From: PETER SHAW
Sent: 19 May 2020
To: Sian Eggington
Subject: RE: Reference: R/58/20/HH

1. The application must also include a new shed in the outside amenity area to the holiday let. Therefore, a new site plan & details of the shed must be requested & the description changed.

**Palm Cottage, 62 Ash
Lane, Rustington
BN16 3BT
Ref. 2376**

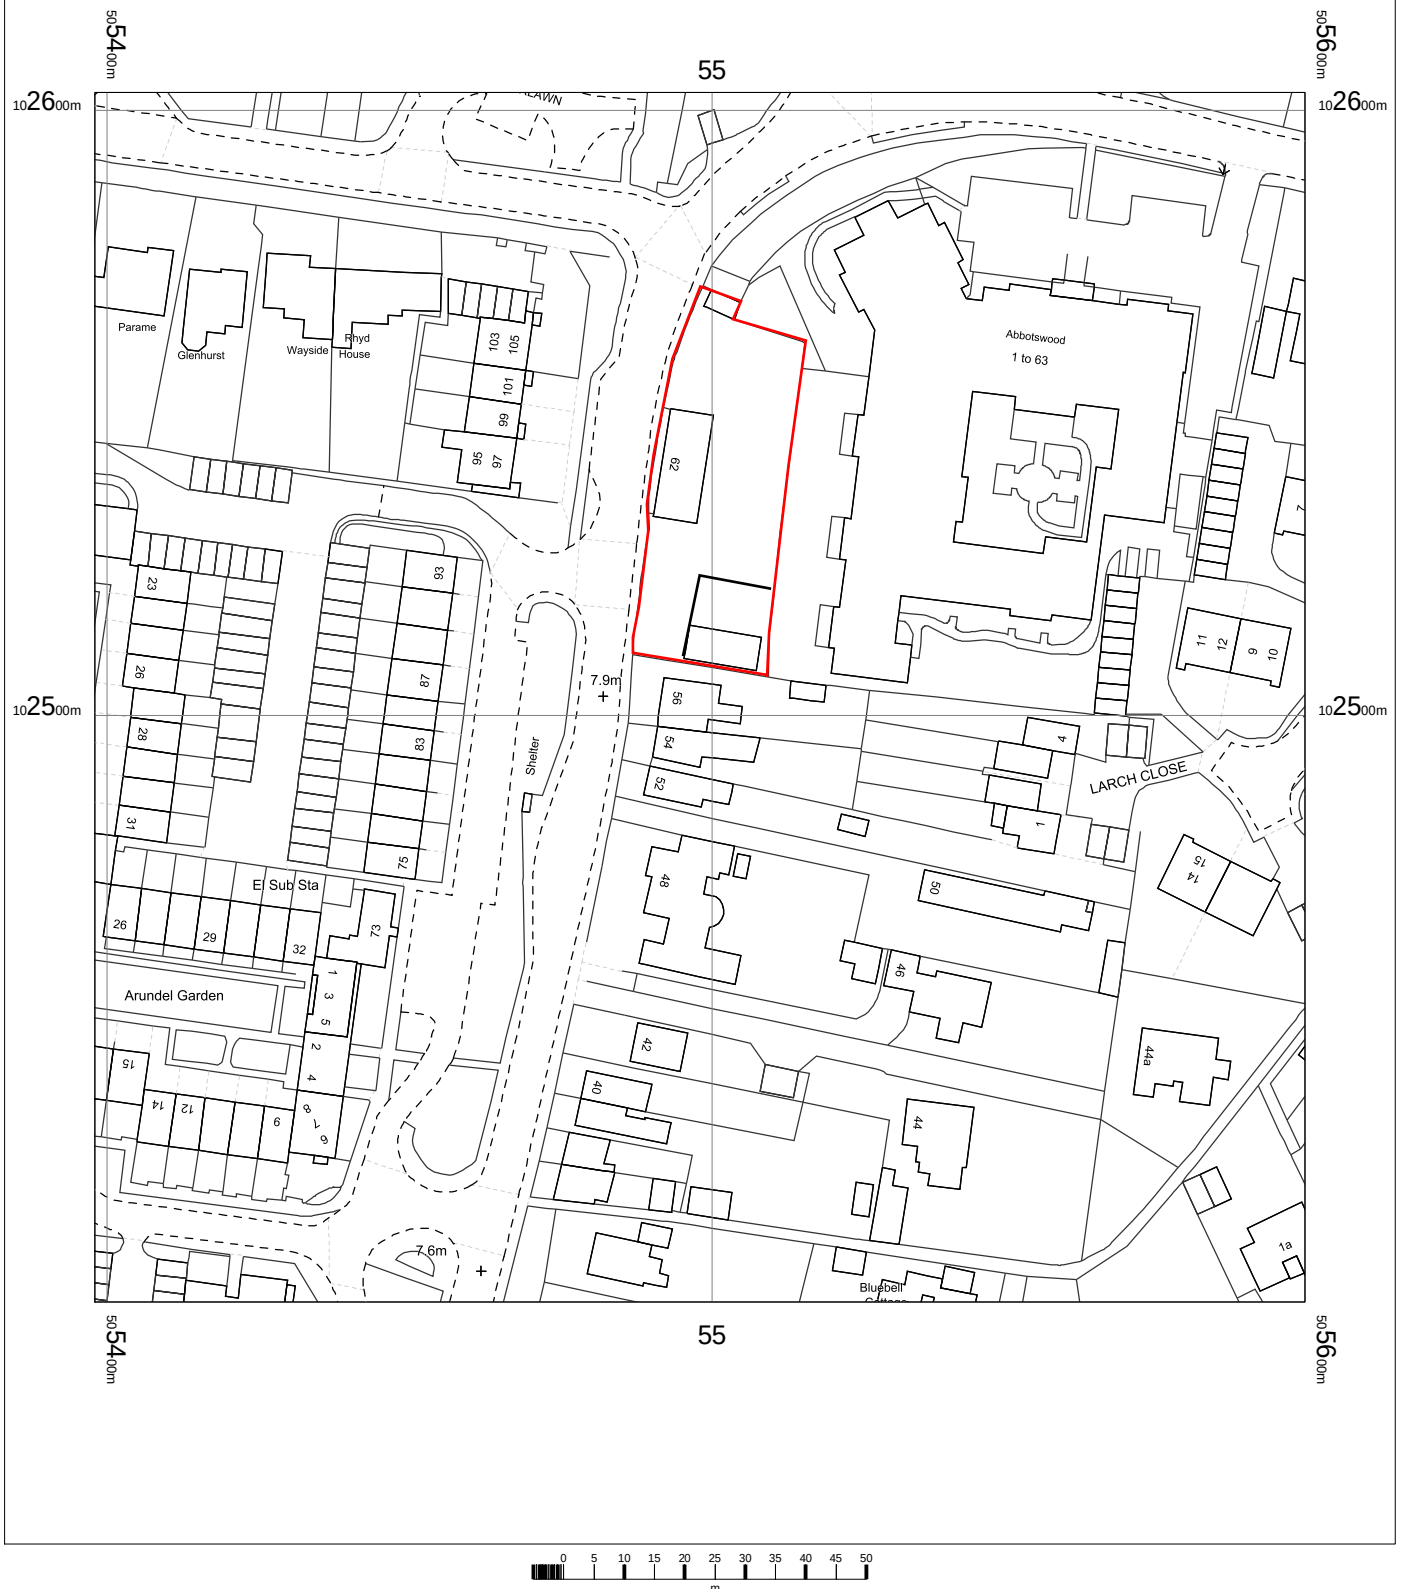
6. The red site outline must include the access to the site from the public highway. As the address given is Palm Cottage please outline the whole site in red. Please review and amend accordingly.
